Recommendation Report for Planning Permission for Works or Extension to a Dwelling

REF NO: FP/232/21/HH

LOCATION: 63 Downveiw Road
Felpham
PO22 8JA

PROPOSAL: Removal of existing conservatory & erection of single storey side & rear extensions.

PROPOSED SINGLE STOREY EXTENSION AT 63, DOWNVIEW ROAD, FELPHAM
FOR MR. & MRS. B. MATTHEWS.

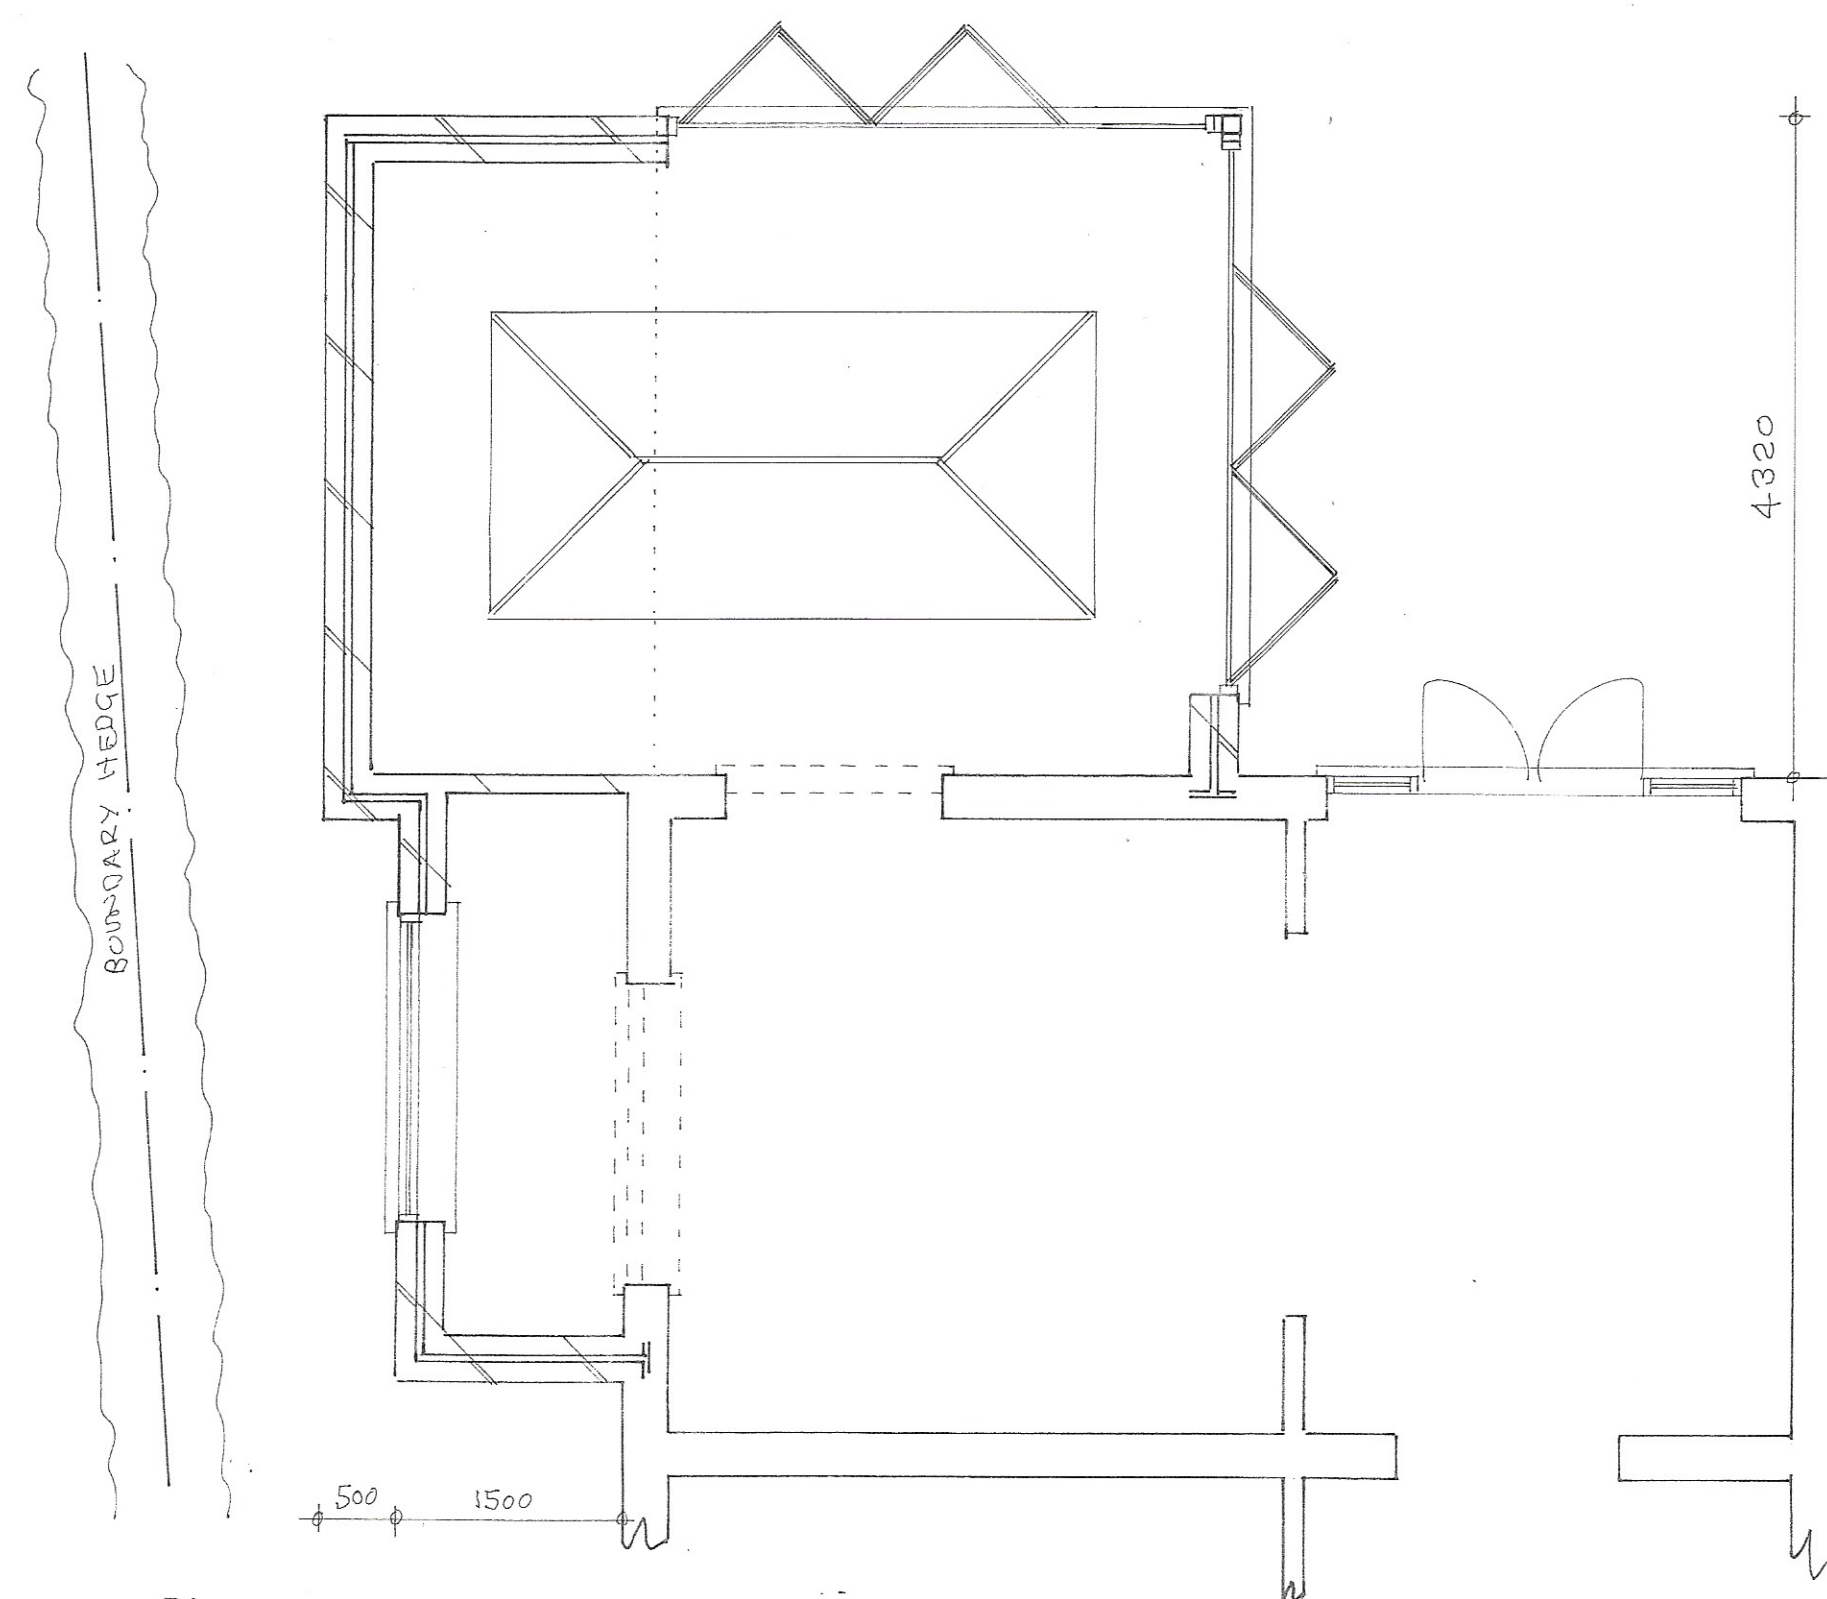
The side extension will have a width of 3.9m and a depth of 1.5m; the rear extension will have a width of 6.1m and depth of 4.3m. Both parts of the extension will have a flat roof, contrasting to the pitched roof of the existing dwelling. However, given the size and location, it is not considered to significantly impose upon the visual appearance of the property and will have minimal impact. Being to the rear of the property, the proposal is not easily visible from the street scene, as previously mentioned. There is potential for restricted views of the side extension at certain positions from the street, but these are limited due to the hedge which sits on the southern perimeter of the property. Given this, and considering the distance the proposal retains from the front boundary, the extension imposes little intrusion on the character of the area.

The extension will wrap around the side and rear elevation of the property. It will have a flat roof at a height of 2.8m. The extension retains a distance of 1.3m to the south, 15.5m to the west and 7.1m to the north boundaries; and given it is single storey, the proposal will not result in adverse overbearing or overshadowing. Due to the distance of the proposal from the nearest side boundary being greater than 1m, it is in compliance with D DM4 of the Arun Local Plan.

The proposal consists of one large window to the south wall of the side extension and two bi-folding doors on the west and north elevations of the rear extension. The rear extension additionally includes a large skylight in the centre of the roof. The only feature considered to potentially pose risk is the window on the south elevation, as this is facing towards the neighbouring property. However, due to the height of the window, and the location of neighbouring windows being a significant distance away, it is not considered to pose a risk of unacceptable harm upon the neighbours privacy and residential amenity. The other features included on the extension do not result in adverse overshadowing, overlooking or overbearing upon neighbouring properties. This is due to views of rear neighbouring properties being highly restricted by a number of trees that line the rear boundary, and the height and distance the extension is from them. The neighbouring properties to the north are not affected, as any potential views from the extension are blocked by a neighbouring garage located next to the boundary. Additionally, the neighbouring property is set back from the rear elevation of the existing dwelling, and is therefore not clearly visible.
